Application for Planning Permission for Works or Extension to a Dwelling

Development: Extensions to dwelling: Two-storeys at north-east side of house and single storey extension at south-east / rear of house
Location: 5 Dalloway Road Arundel BN18 9HJ

FIRST FLOOR PLAN
as proposed

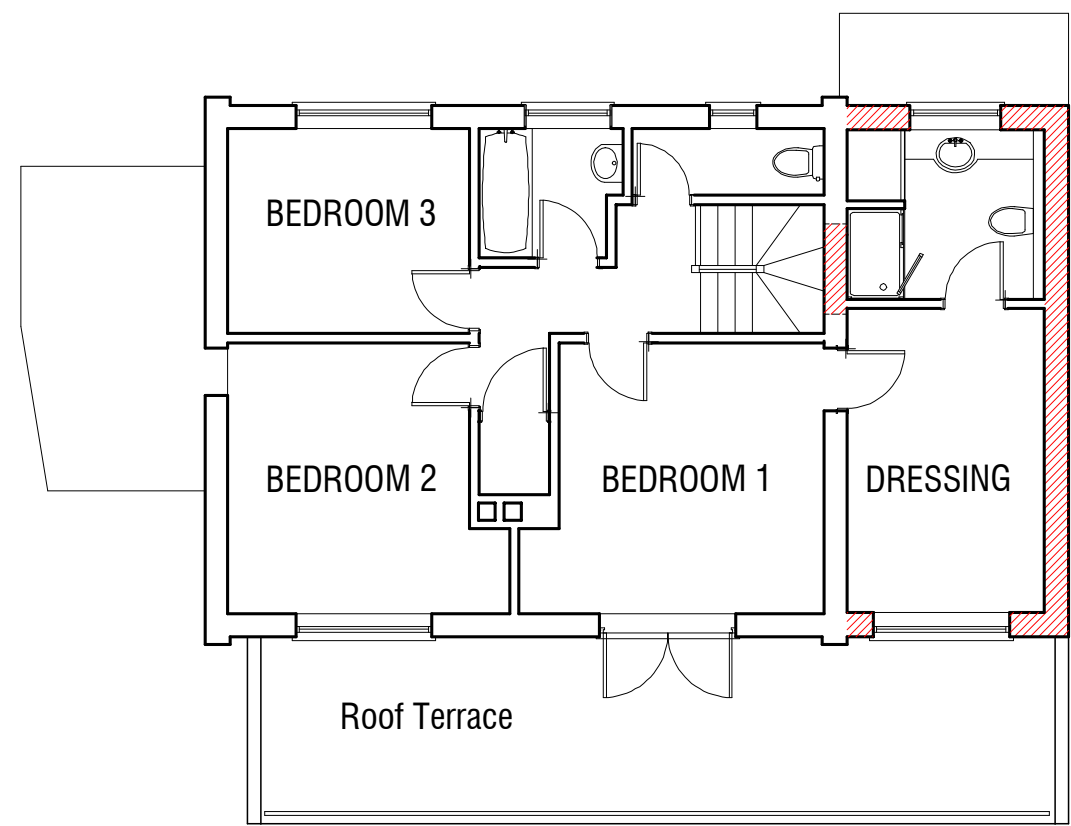
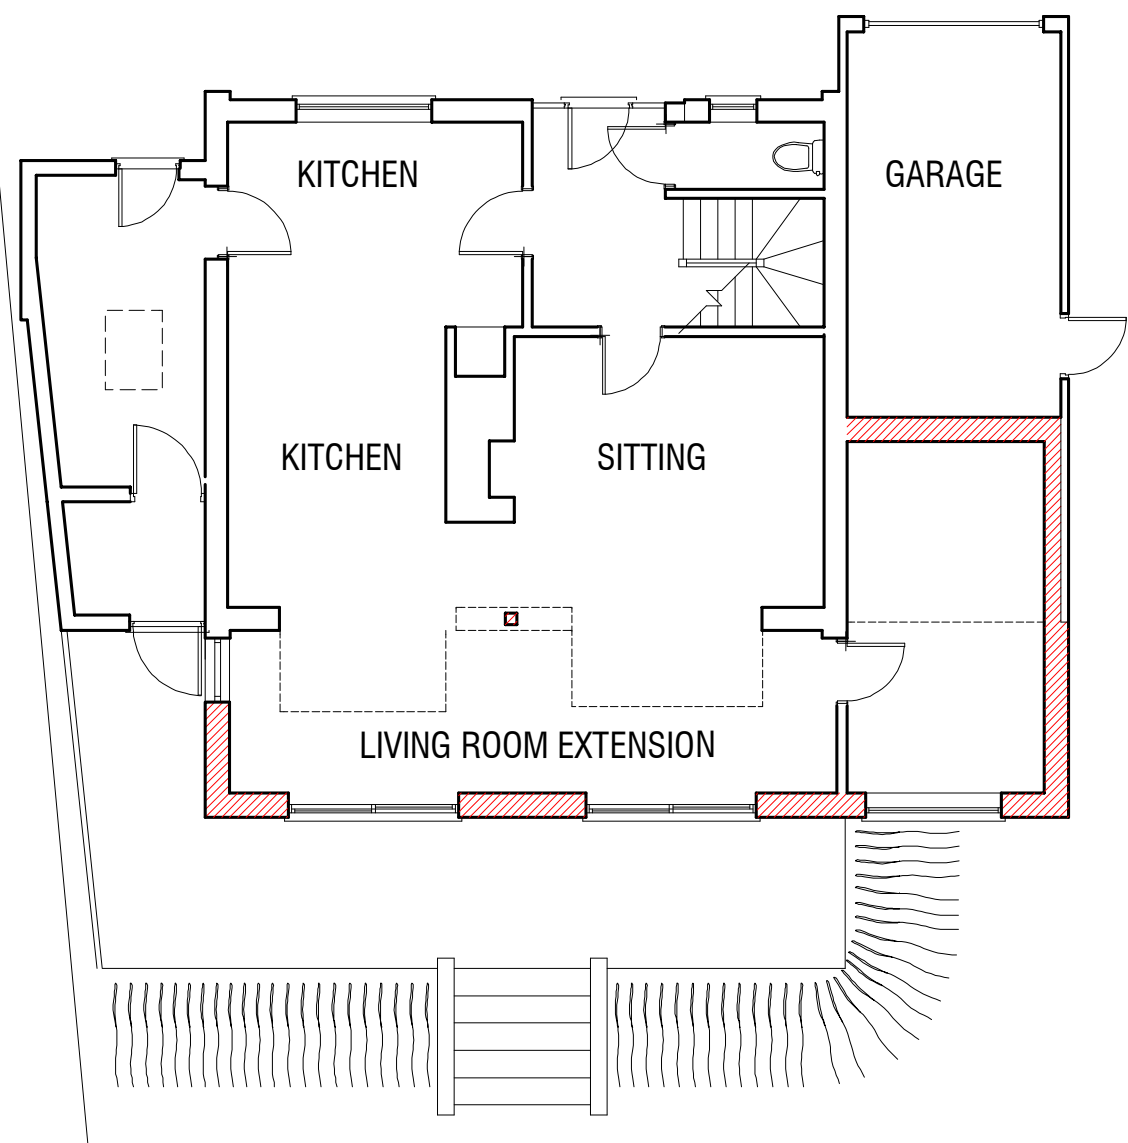
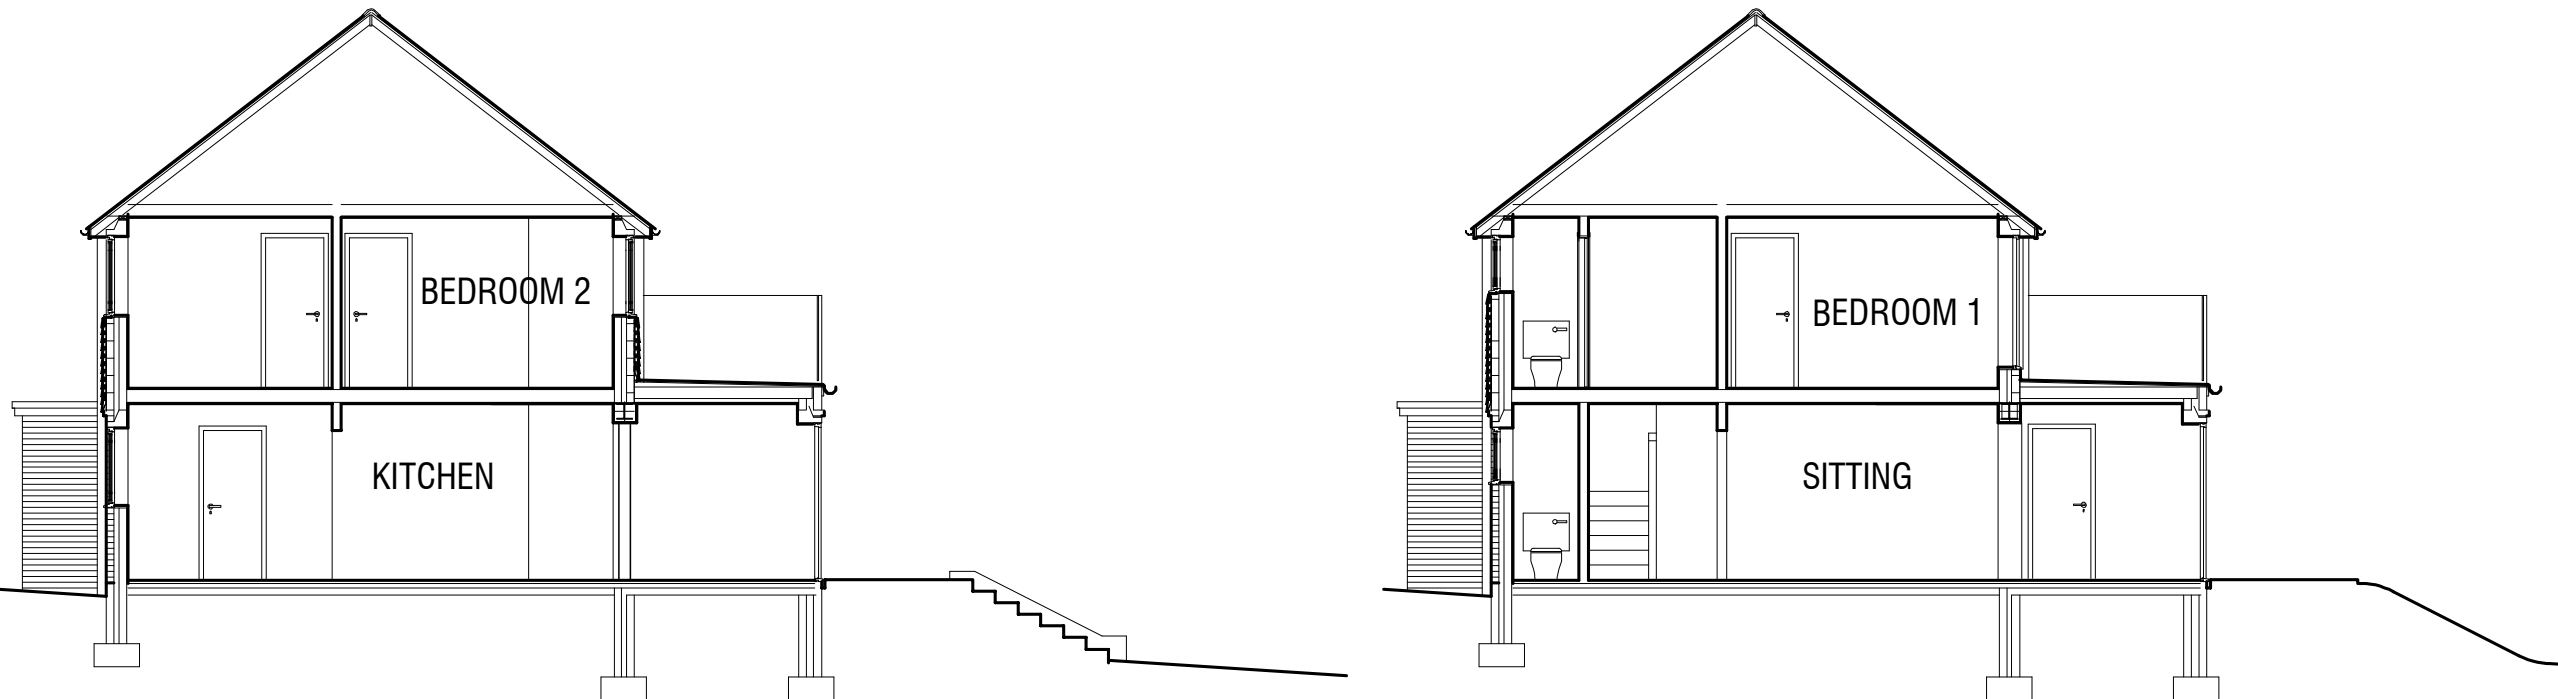
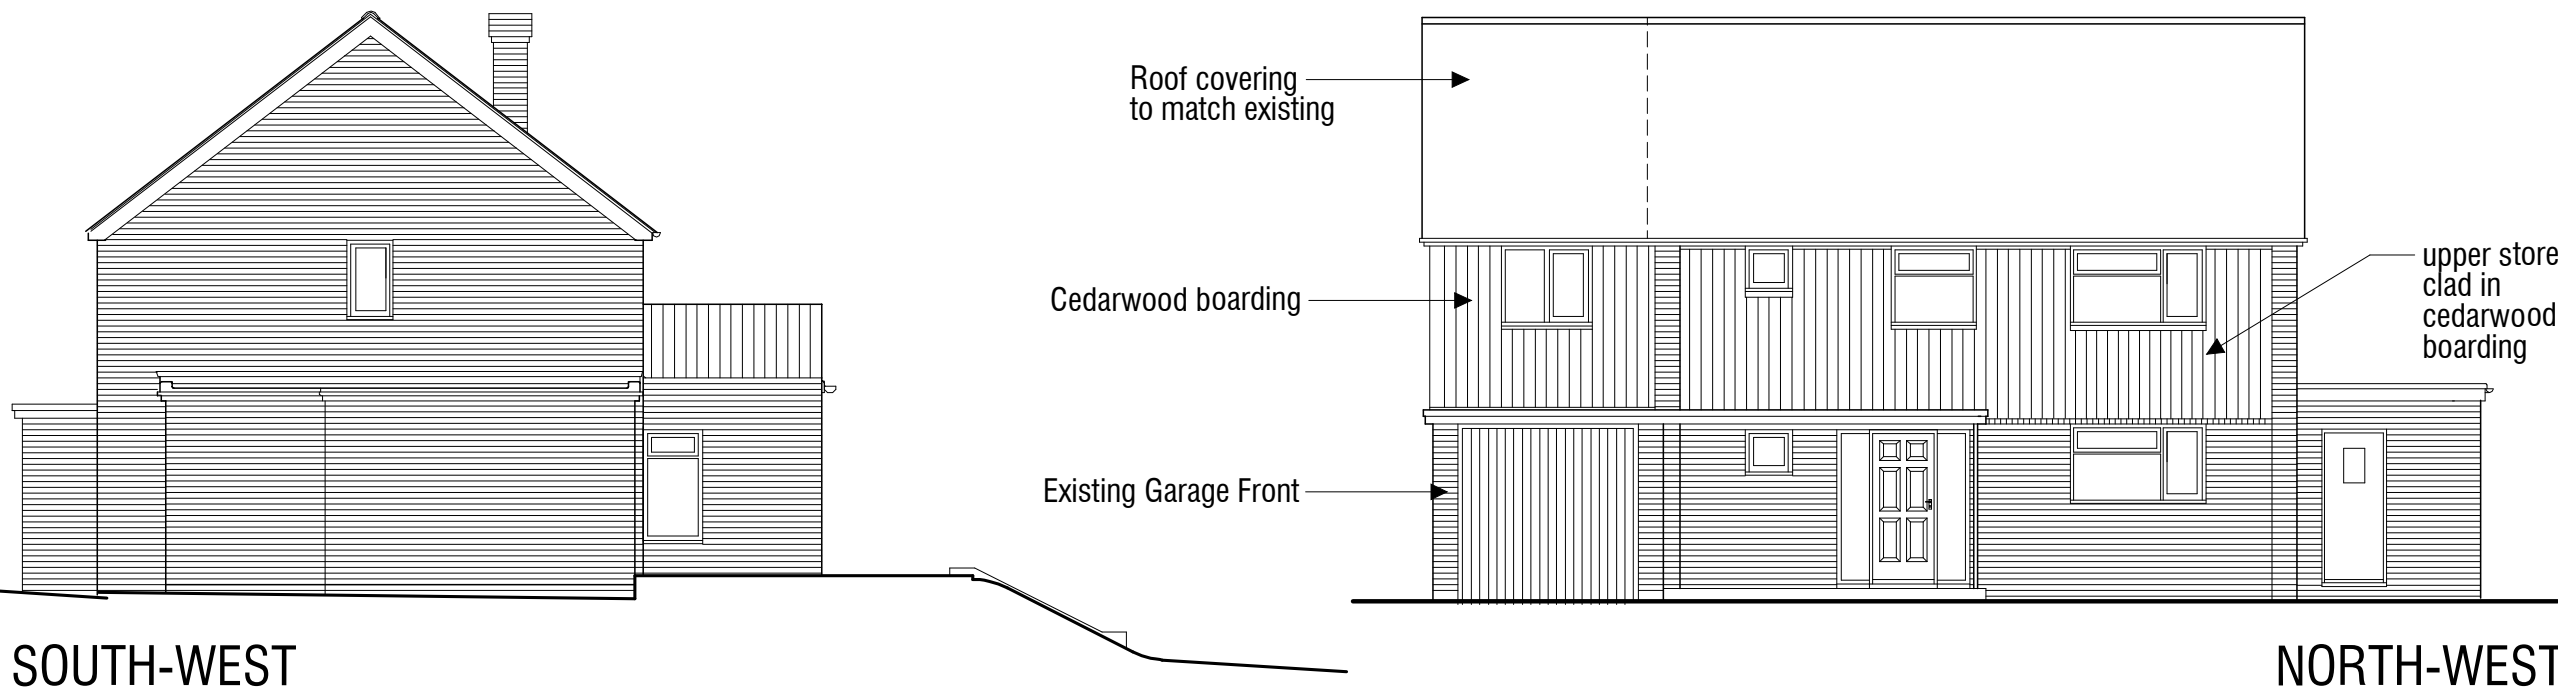
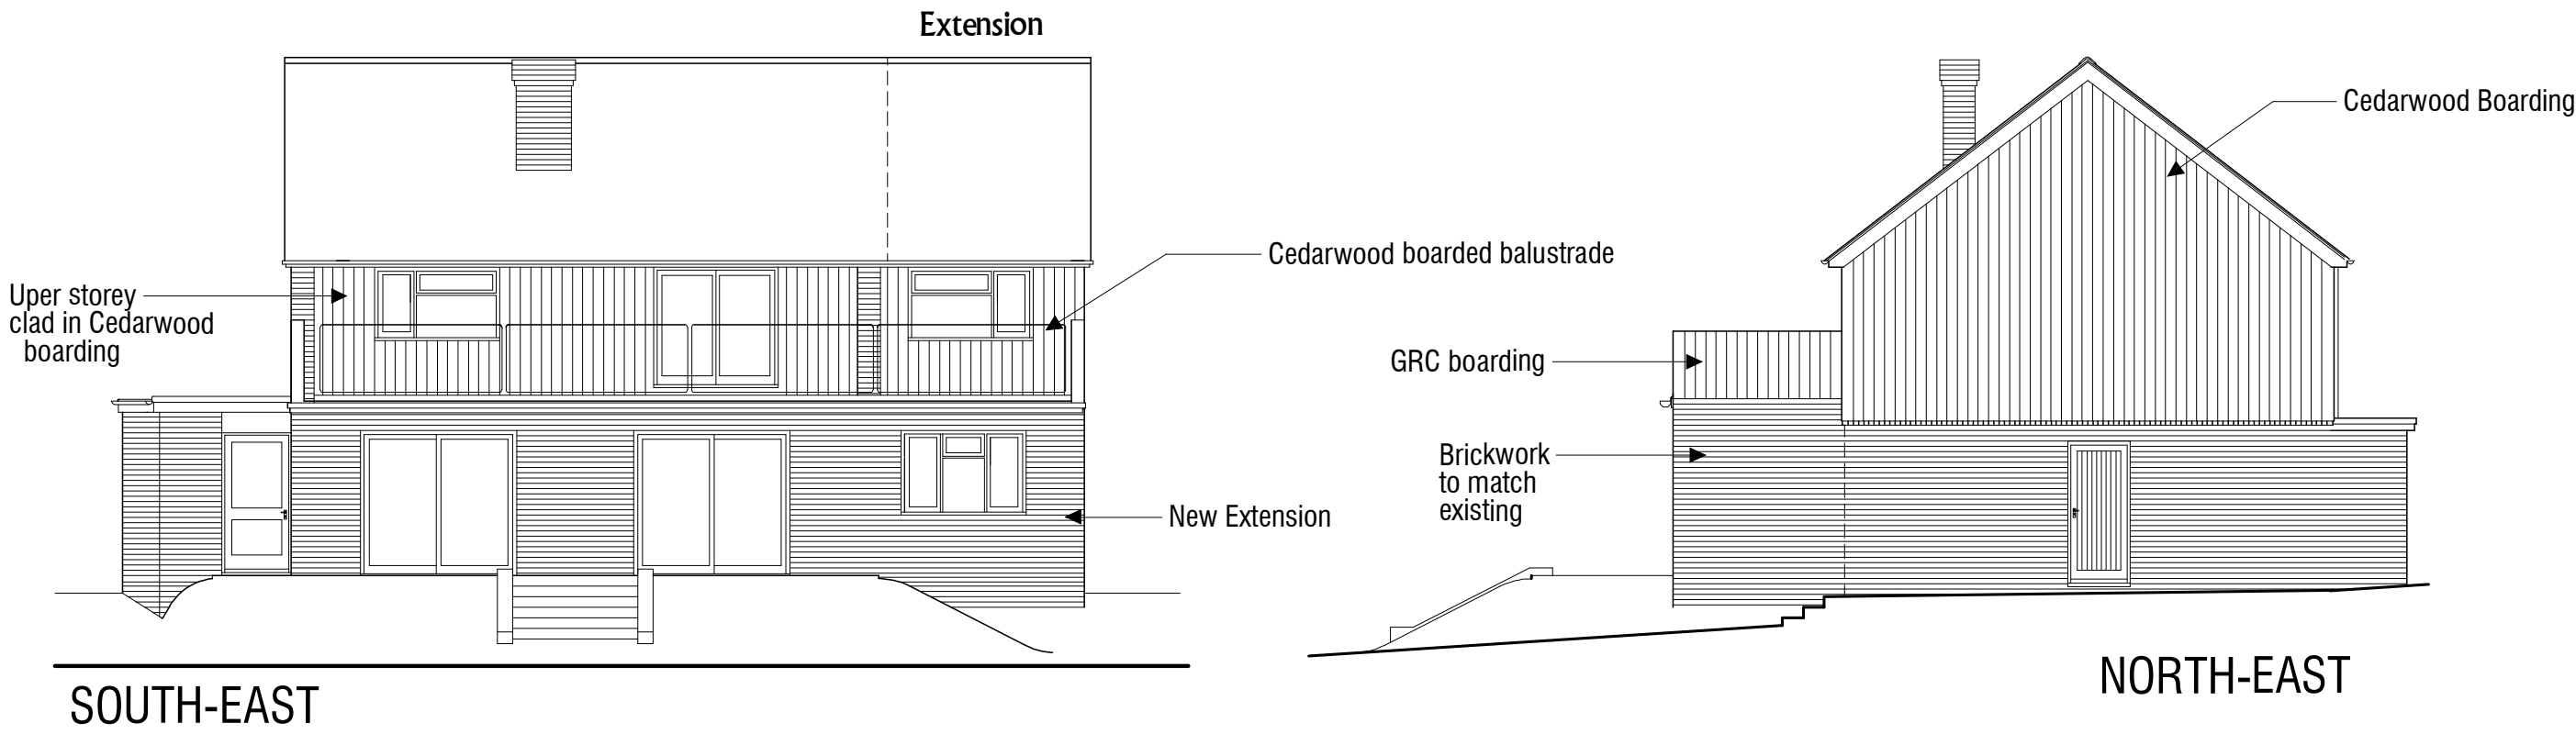
Inconsistent: The windows are inconsistent between the south west elevation and first floor plan

BLOCK PLAN 1/500 Scale

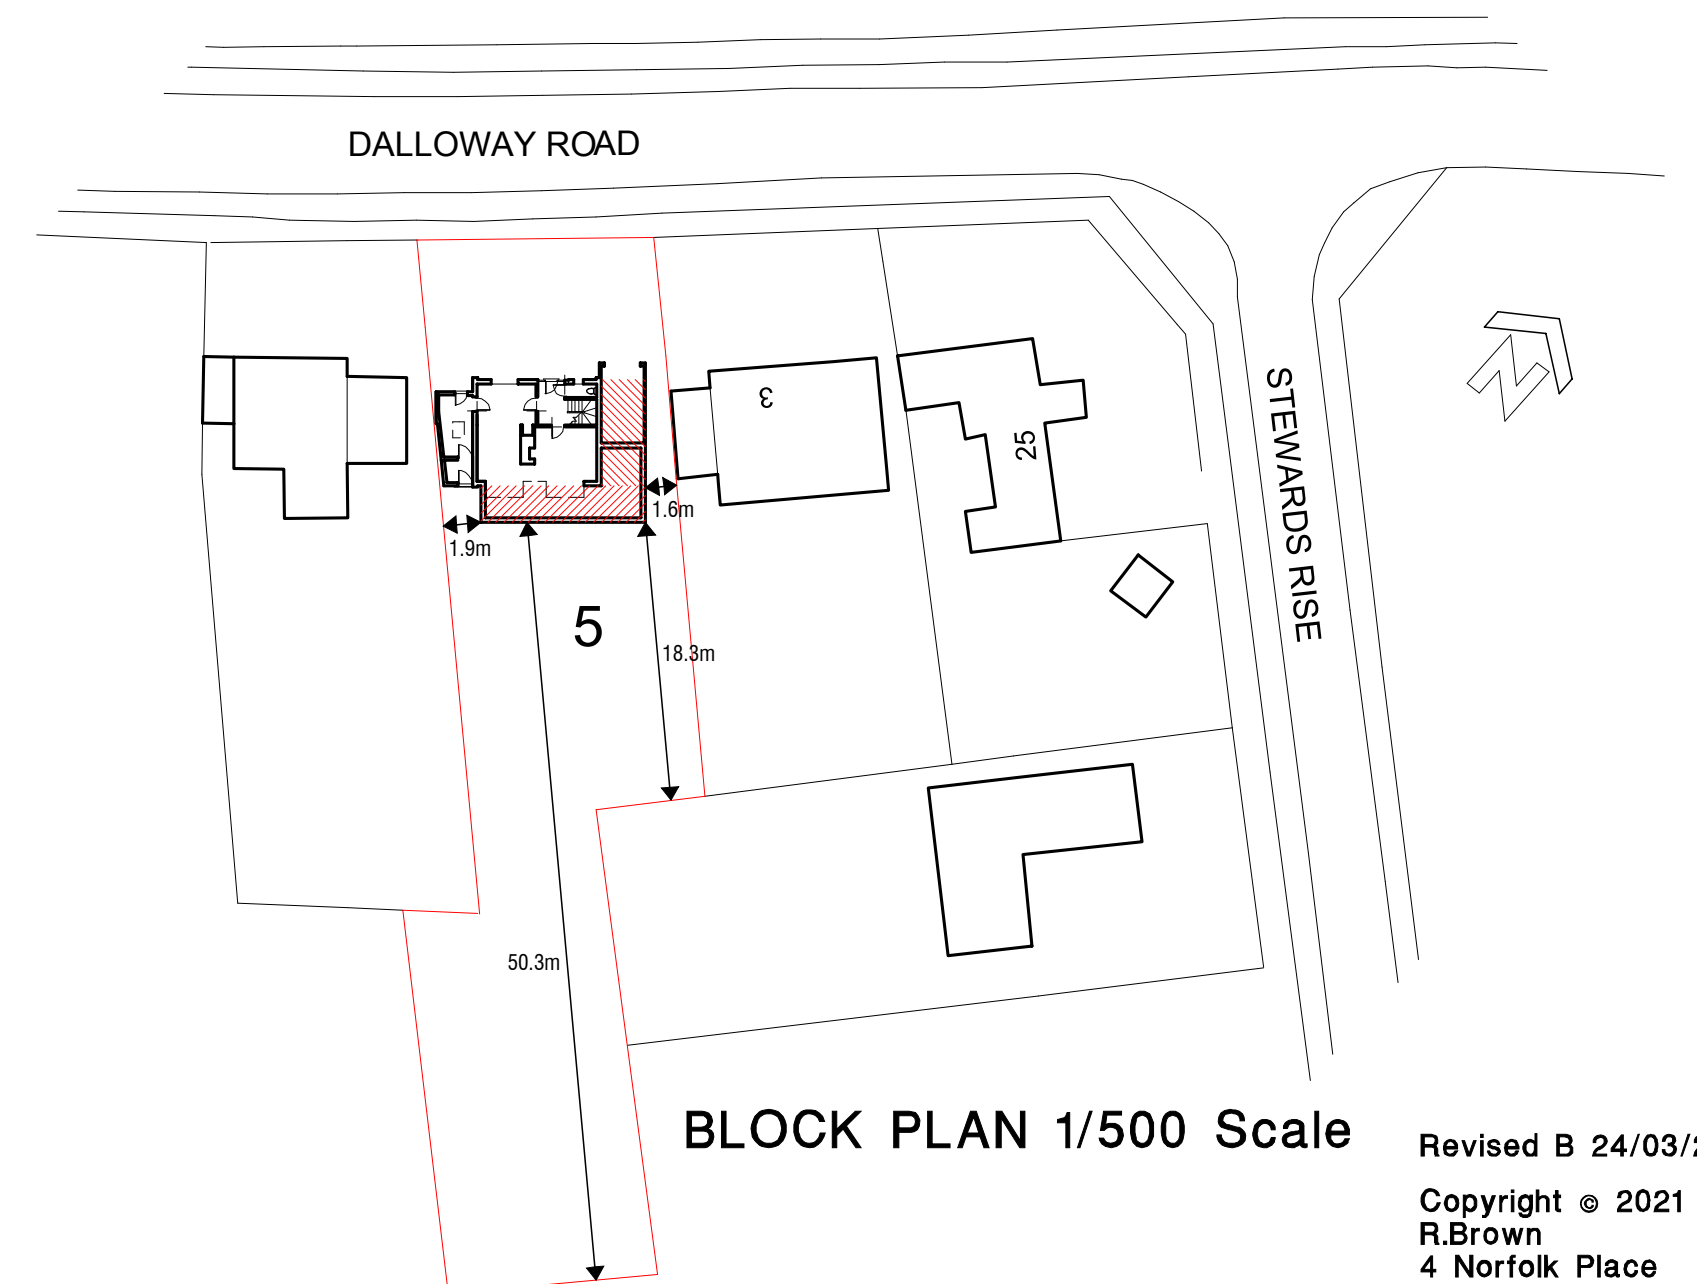
Dimensions: You are required to include dimensions on the block plan from the proposed extension to all site boundaries.
